Office of  
Environment  
& Heritage

Our Ref: DOC19/383405  
Your Ref: MP 09\_0166 MOD 3

**Re: Updated Response to Submissions Altitude Aspire Residential Subdivision (MP 09\_0166 MOD 3)**

## **Attachment 1: Detailed OEH Comments – Updated Response to Submissions RTS Altitude Aspire Residential Subdivision (MP 09\_0166 MOD 3)**

NEWLAND DEVELOPERS PTY LTD	09-374 16-11-2017
TERRANORA PRECINCT 1 WEST BOUNDARY EARTHWORKS EXTENT	SK 6524 REVISION A

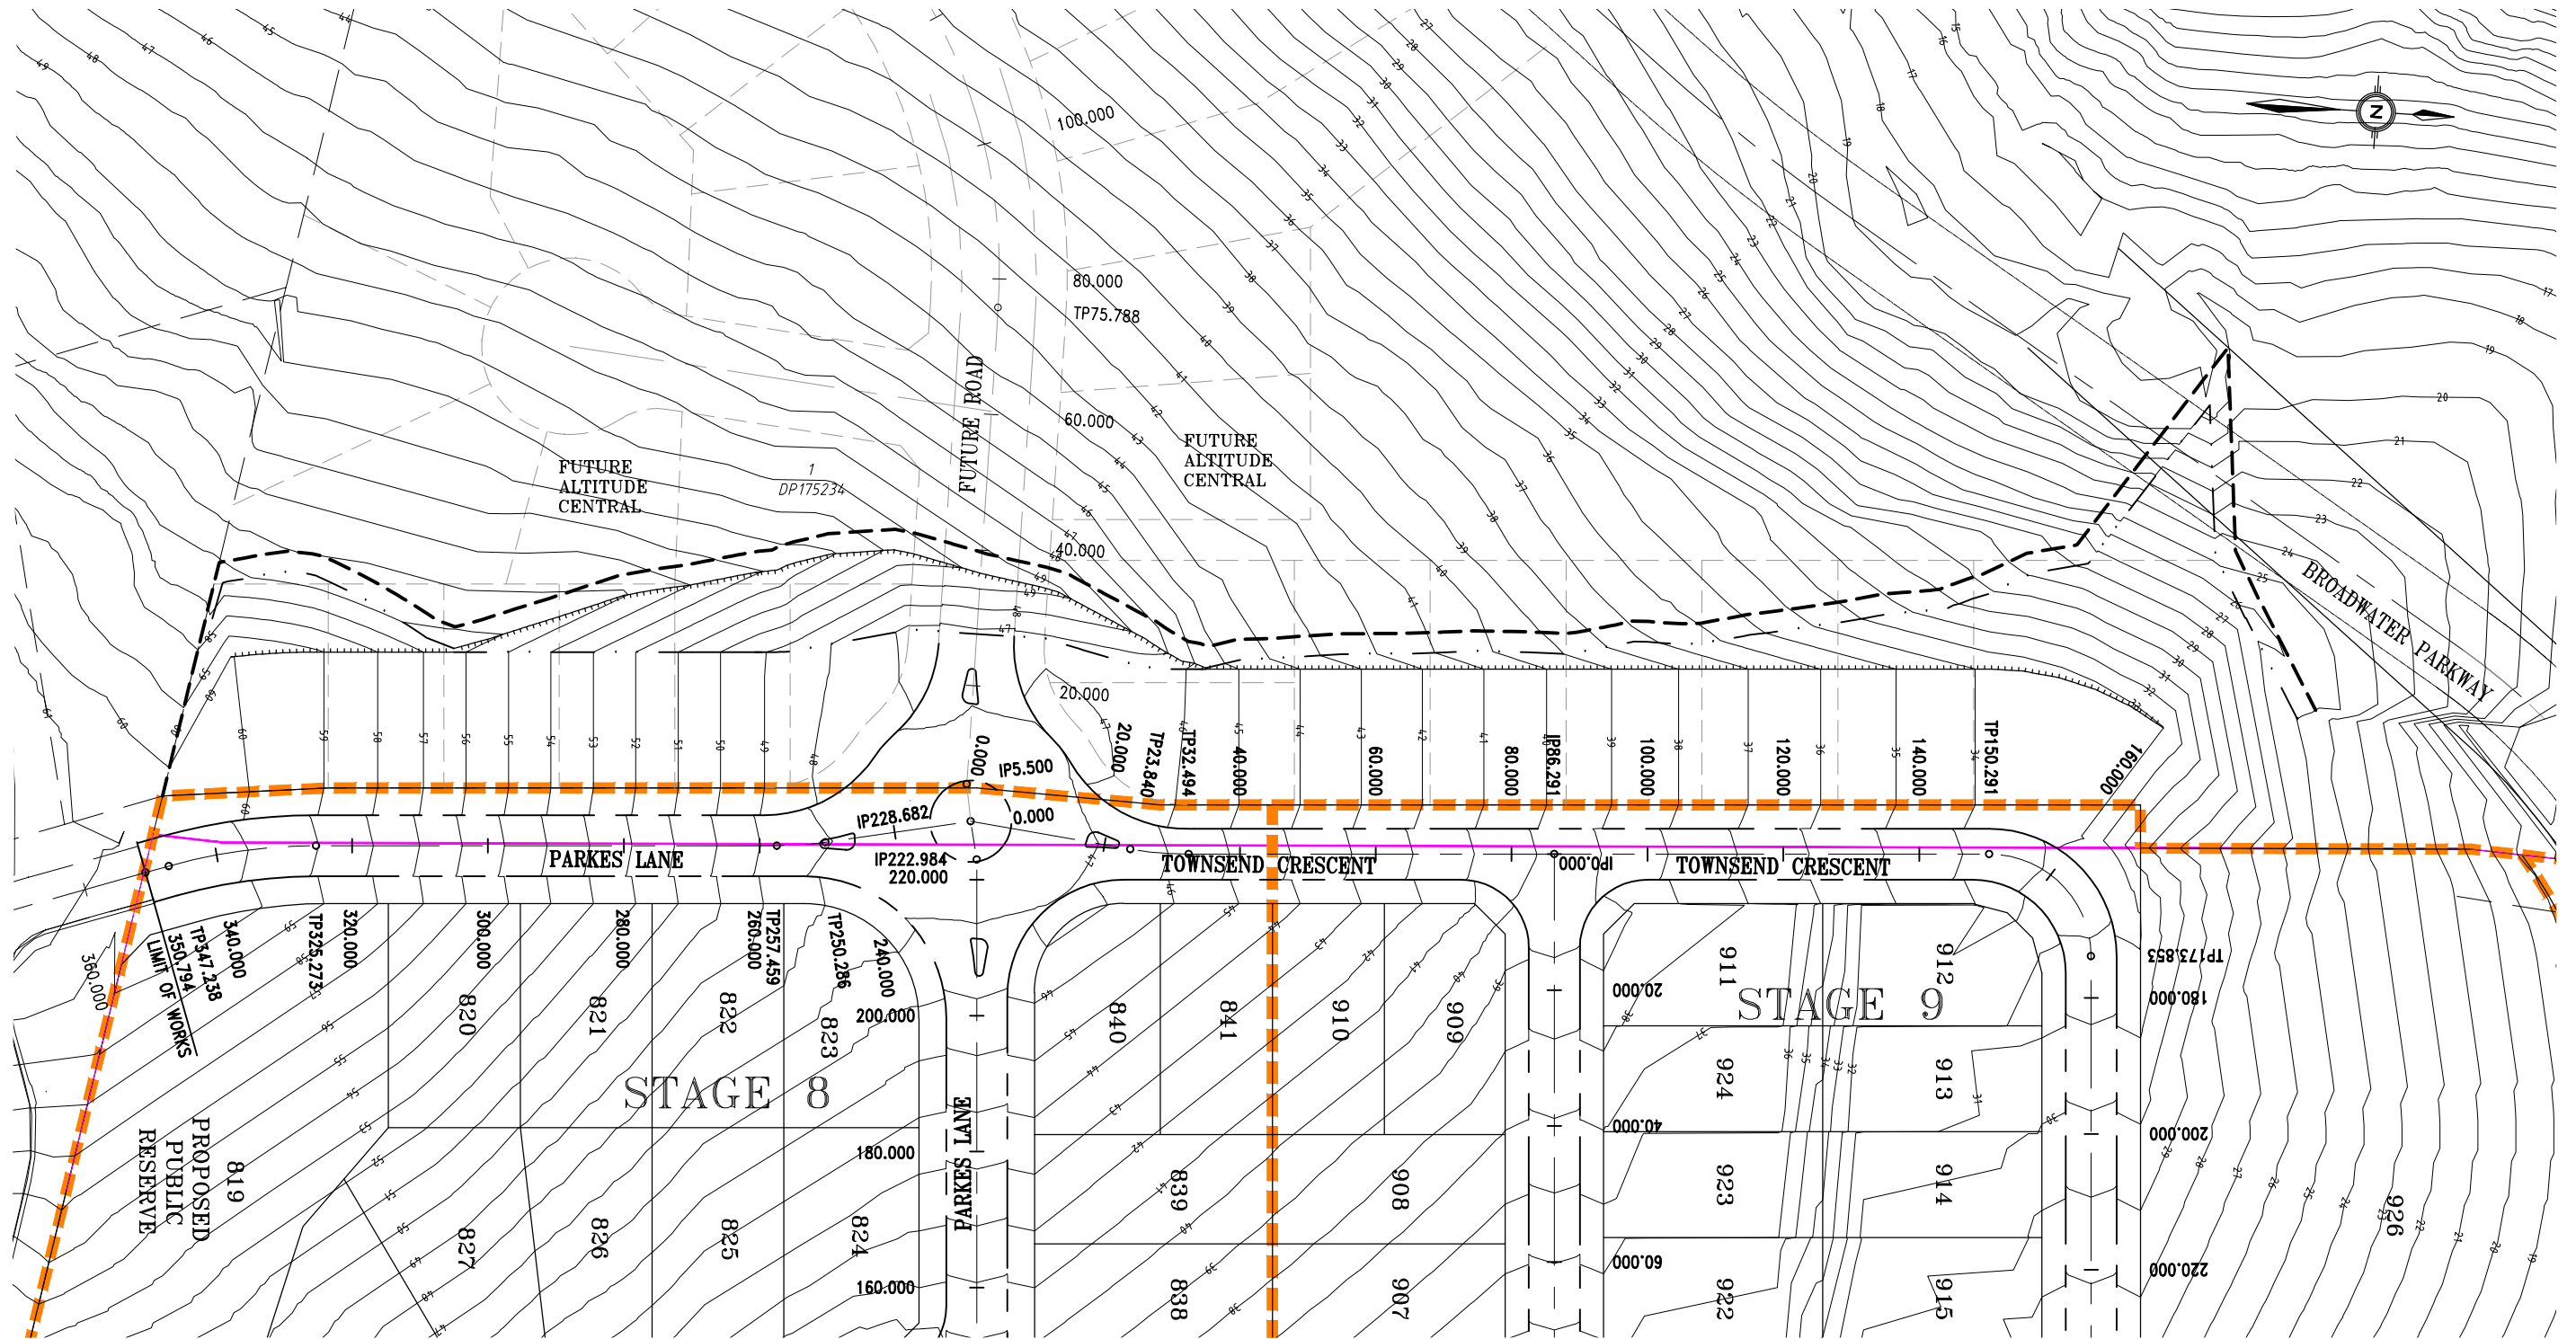
4. The BDAR must provide mitigation measures specific to the bulk earthworks in the development footprint. These should include erosion and sediment control, slope stabilisation, weed control, fencing and demarcation of the work area. No works (including temporary and permanent ancillary construction and maintenance facilities) should be located outside the development footprint. If there is a need for sedimentation ponds or other ancillary development outside the development footprint, then this will require an amendment to the current BDAR and other relevant documents.

The vegetation that straddles the property boundary has only been mapped on the western side of the fence line. This polygon should include all the canopy cover of the trees and other vegetation regardless of where the trunks or fence line are located. Mapping and area calculations for Vegetation Community 1 need to be amended accordingly.
